From: Thomas Callaway
Sent: 02 October 2015 14:56
To: Planning.Responses
Subject: RE: Planning Consultation on A/115/15/DOC

APPLICATION A/115/15/DOC

Site Address: Former Pound Nursery Roundstone Lane Angmering

Works: impused under A/167/14/PL relating to conditions 4, 13, 14, 18, 20 & 23 for protection of retained trees, programme of archaeological work, ecological mitigation report, foul water sewerage disposal, surface water drainage & storage of refuse & recycling bins.

TITLE Typical Gravel Soakaway Detail

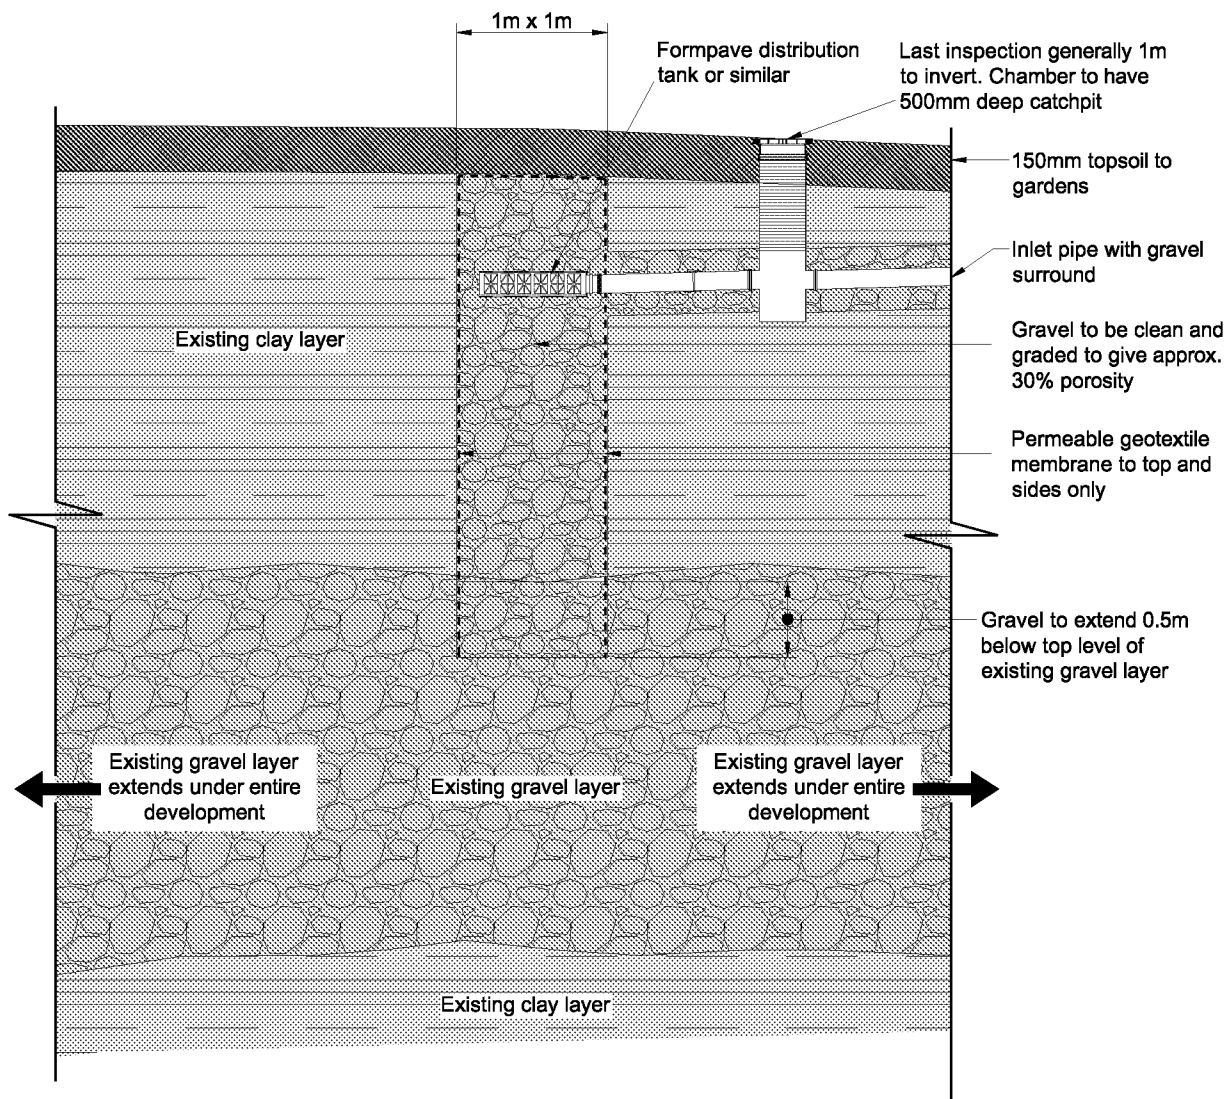
The drainage design is to be equivalent to the Swanbourne Park development, utilising the same system of private soakaways extending to the gravel strata.

The condition for surface water drainage may be discharged based on the submitted section view of the private soakaways and the proposed percolation rates.
